Subject: Response to Submissions - Darling Harbour Live Interactive Signage Display System (SSD 7047)

The City of Sydney (the City) has reviewed the Applicant's Response to Submissions (RtS) for the proposed "Interactive Display System" within the Darling Harbour Live development.

T09 - Naming rights and event/precinct information

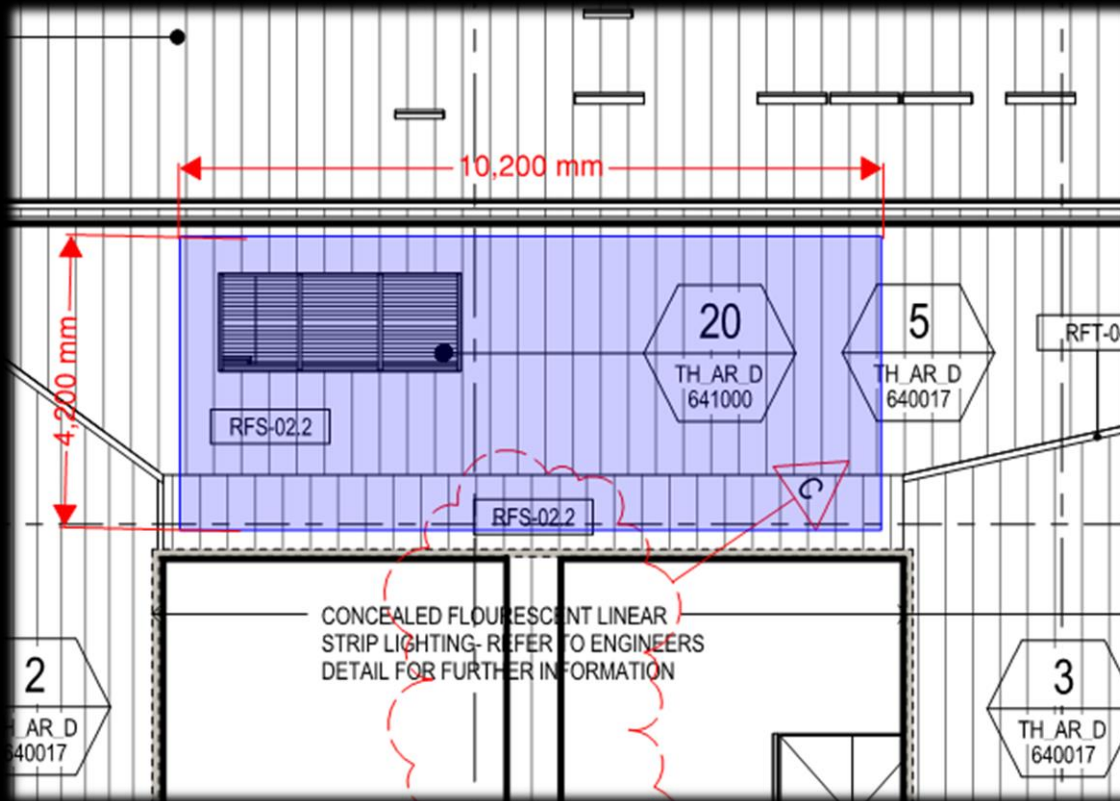
- Inappropriate use of LED signage for building identification. In this regard, the planning report contends that sign T-09 on the southern elevation of The Theatre, being an LED building identification sign, is supposed to be *"an attractive feature for the people of Sydney and Australia to be proud of"*. This is questionable justification at best for staying with an LED concept when the building can be identified by a conventional backlit or other illuminated sign of lesser environmental impact. The LED sign should not be capable of being used for advertising content, as appears the long term strategy.

6 DIGITAL SIGN T17 WEST ELEVATION

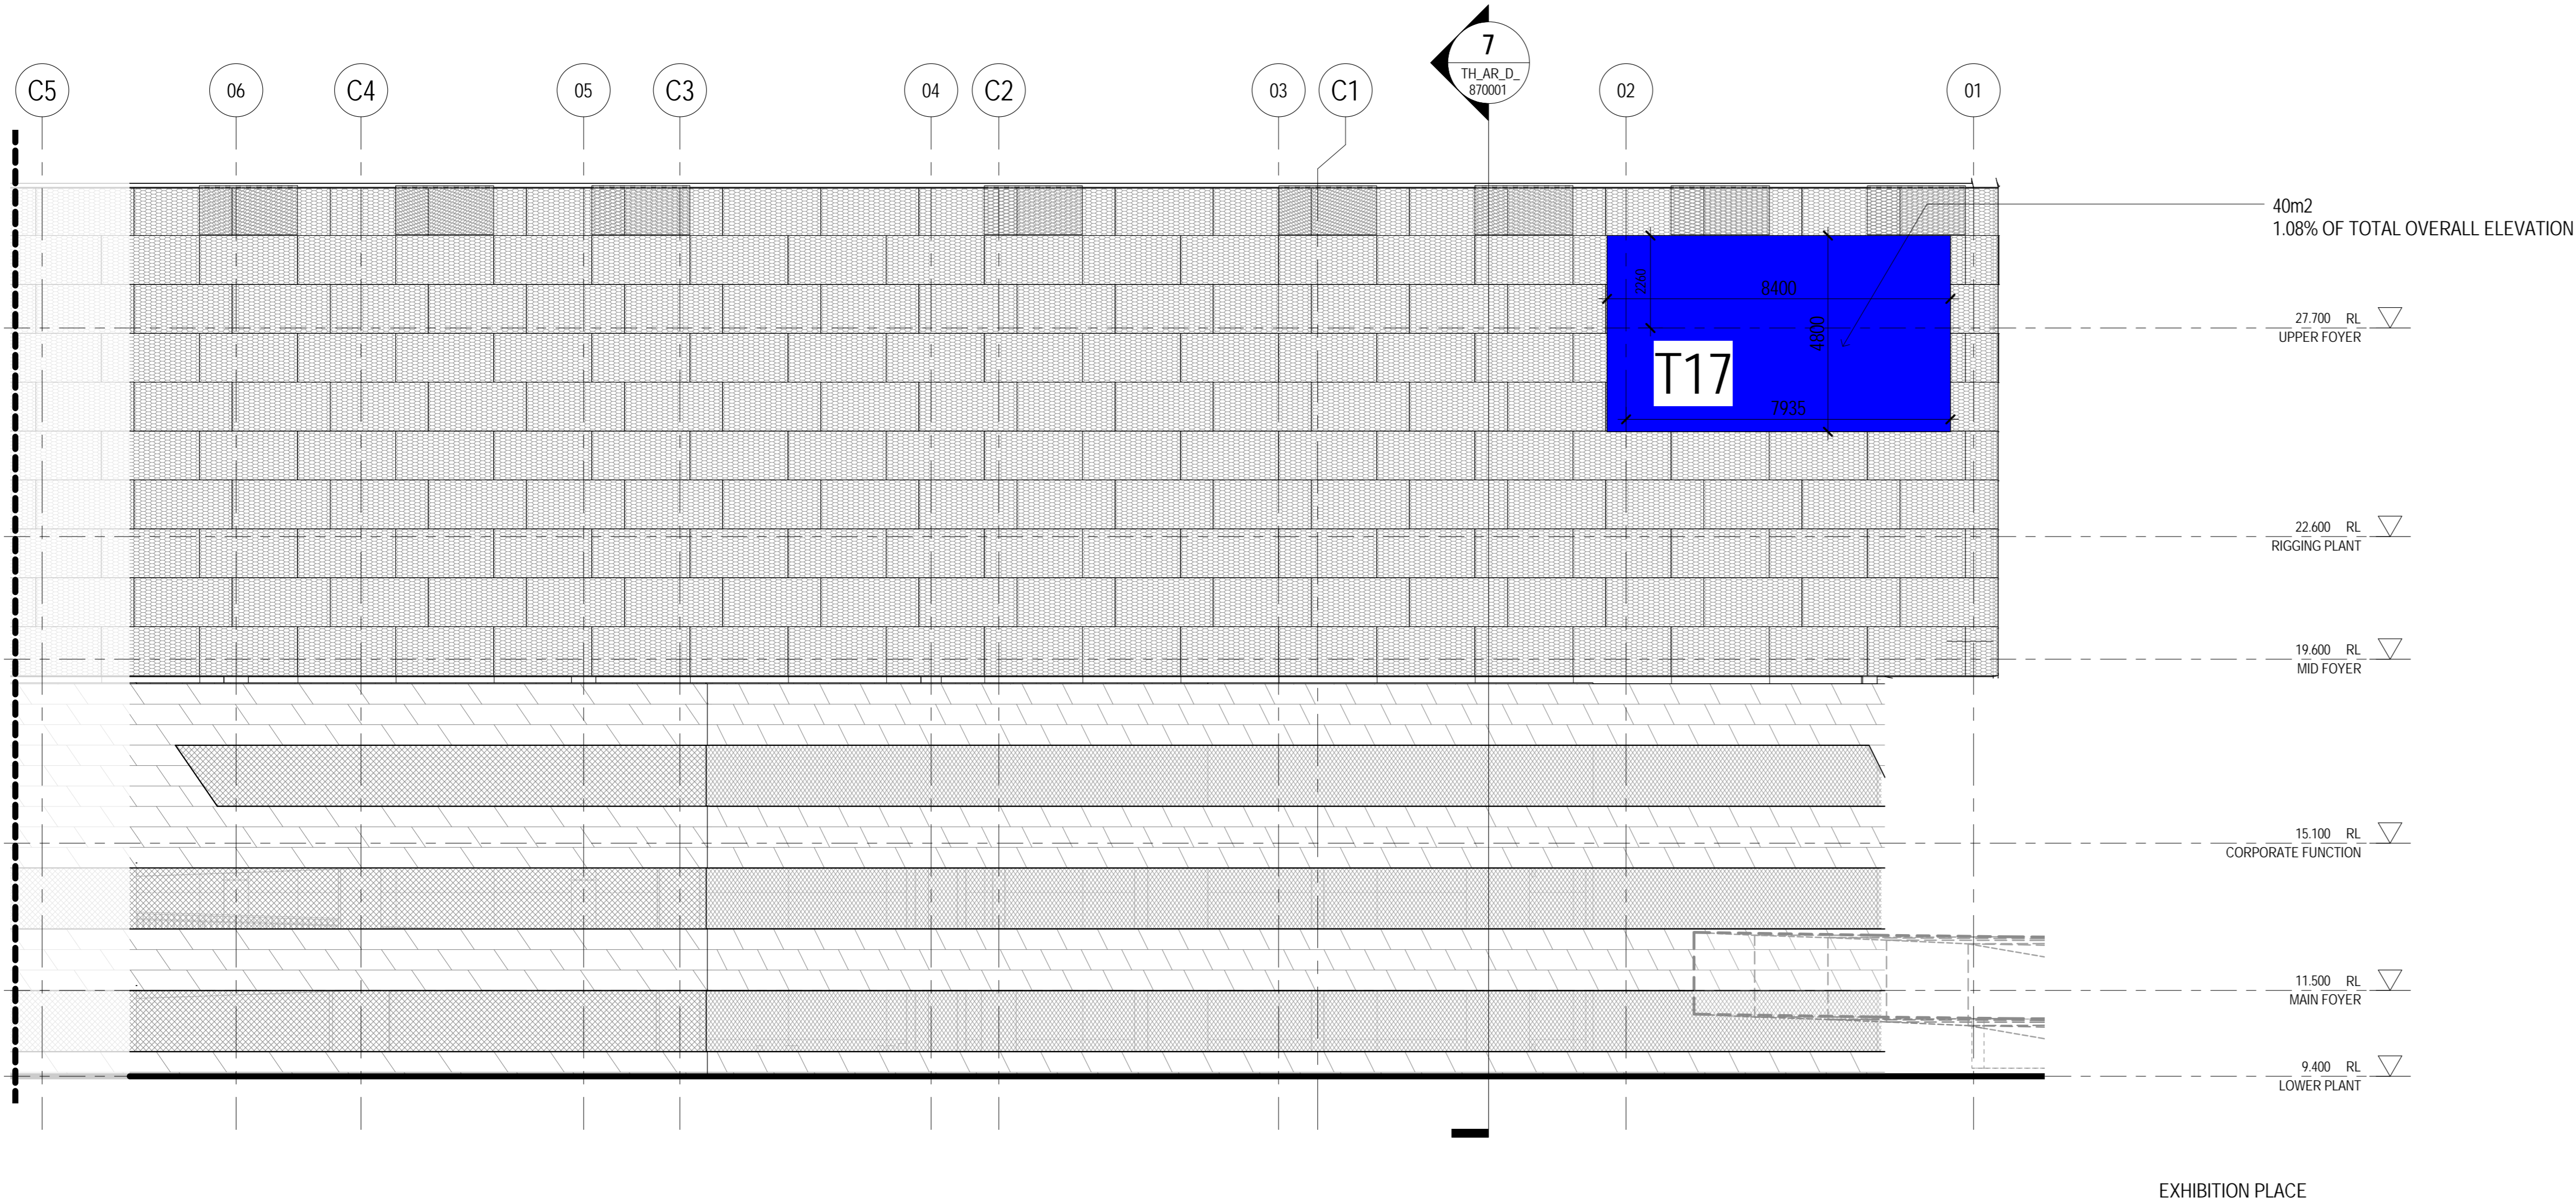
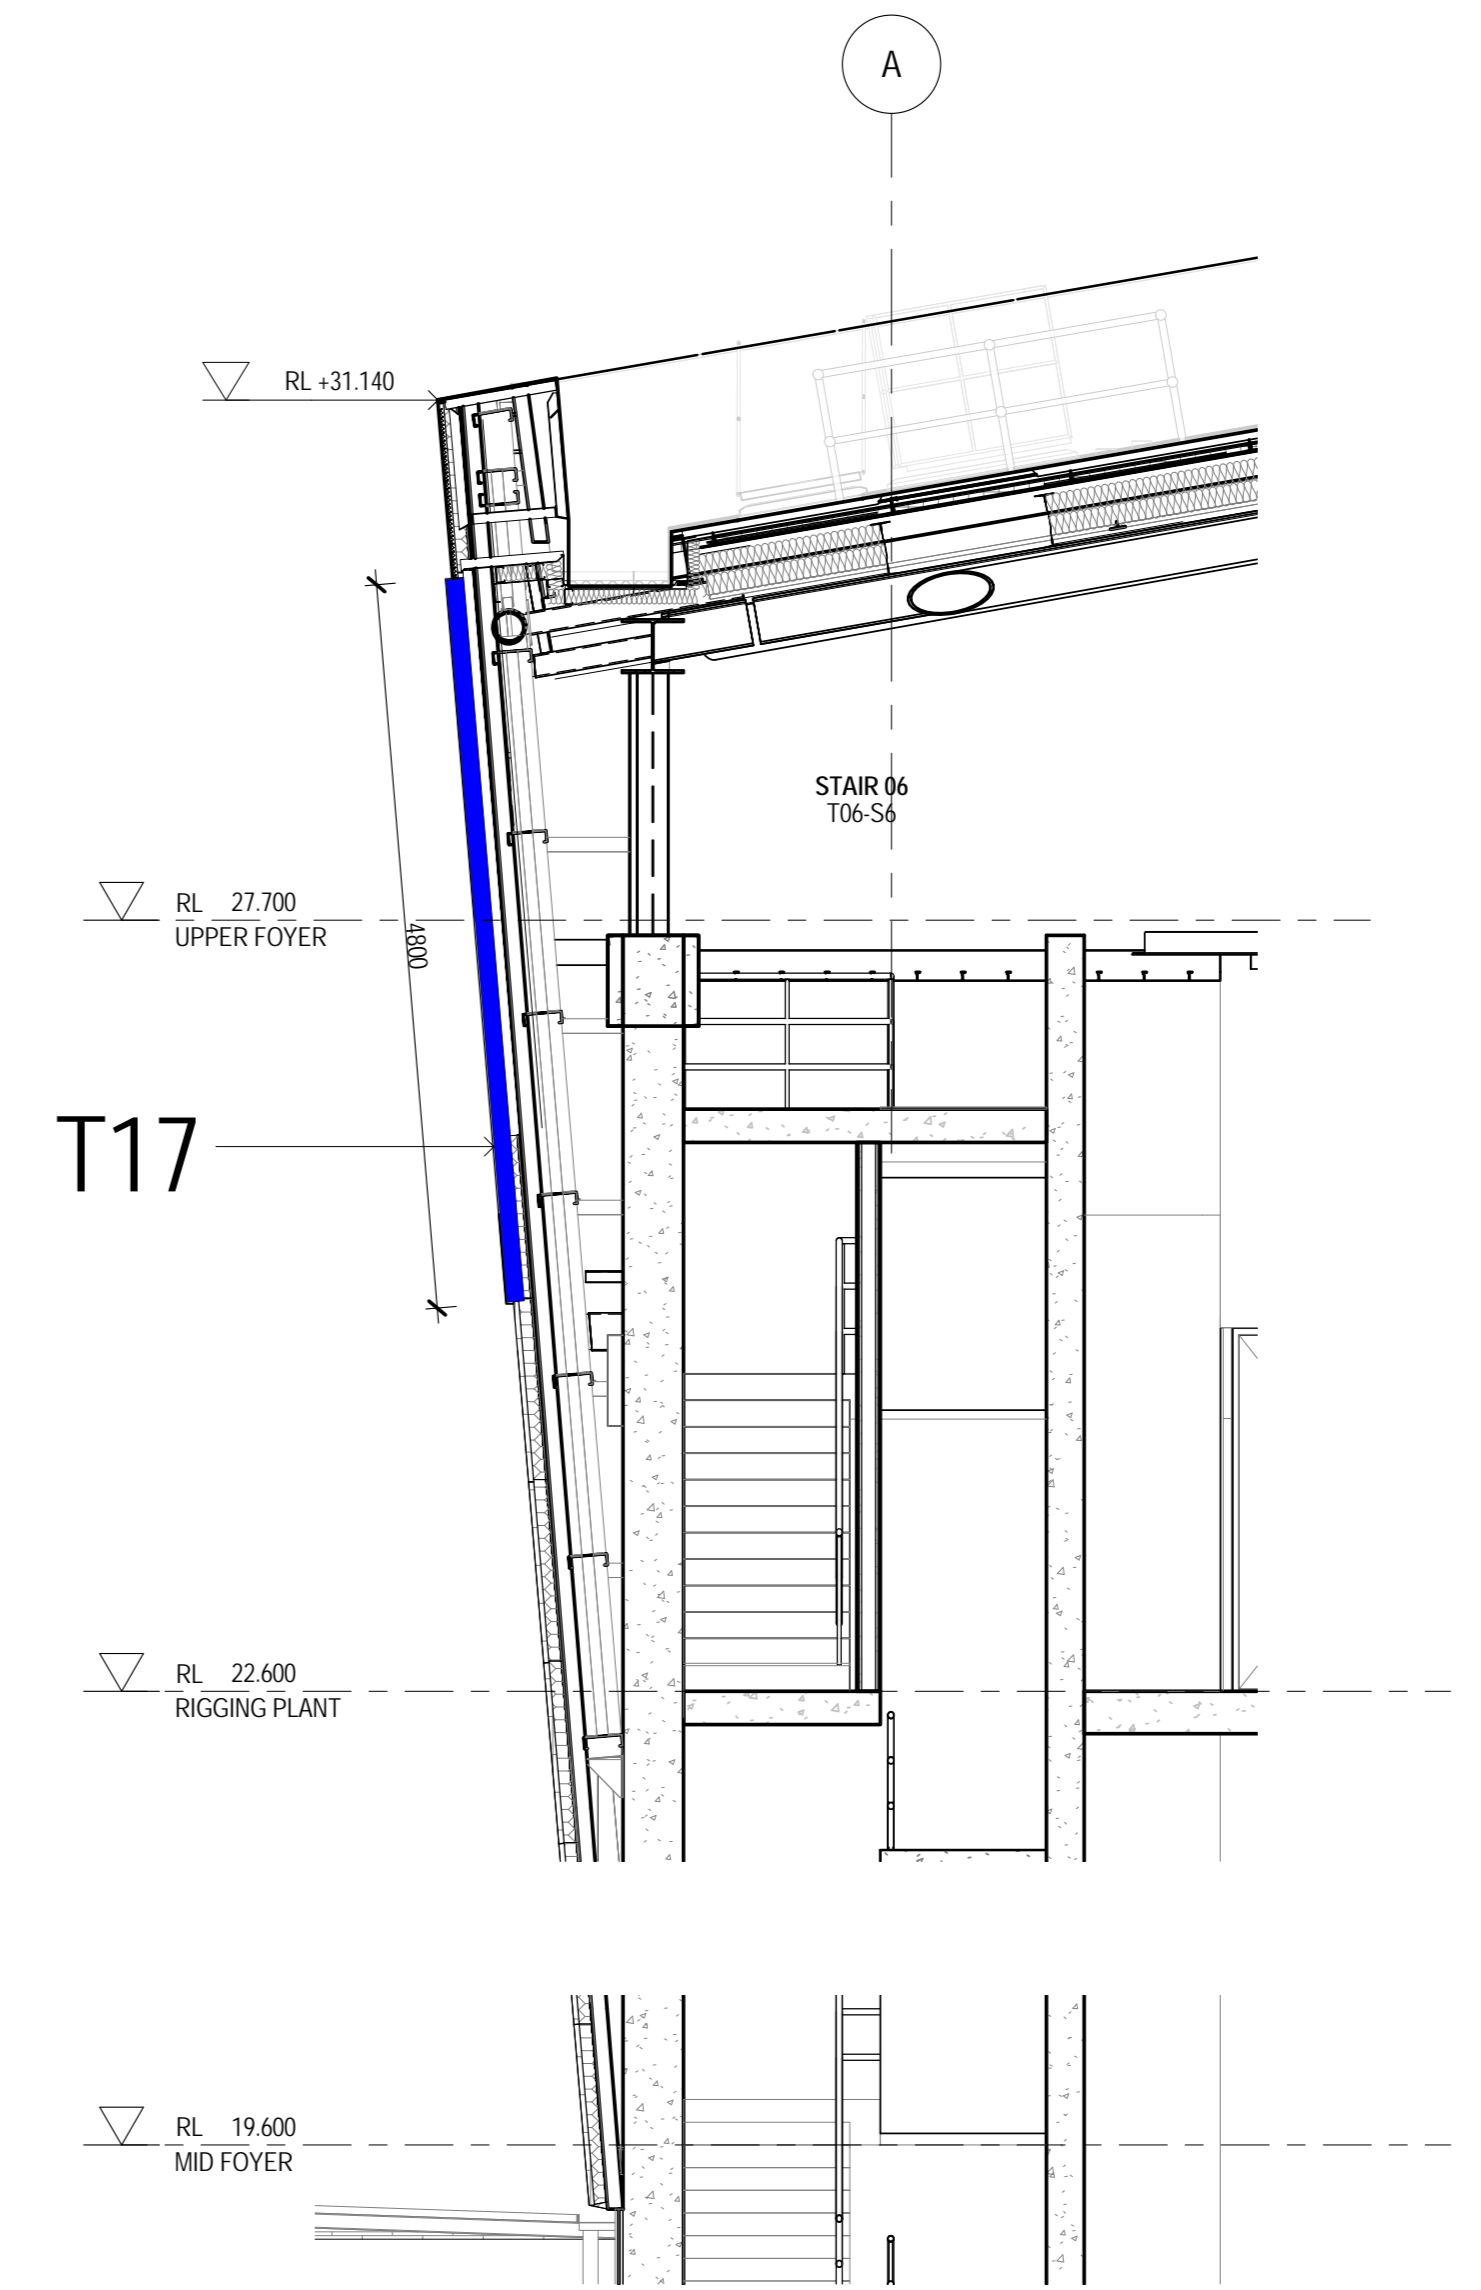
A reduction in size of Sign T-17 has occurred so that it no longer has to address Clause 19 of State Environmental Planning Policy 64. It is noted that the amendment was driven by the Applicant's desire to avoid a compliance issue rather than a reasonable reduction in the bulk and scale of such a prominent sign.
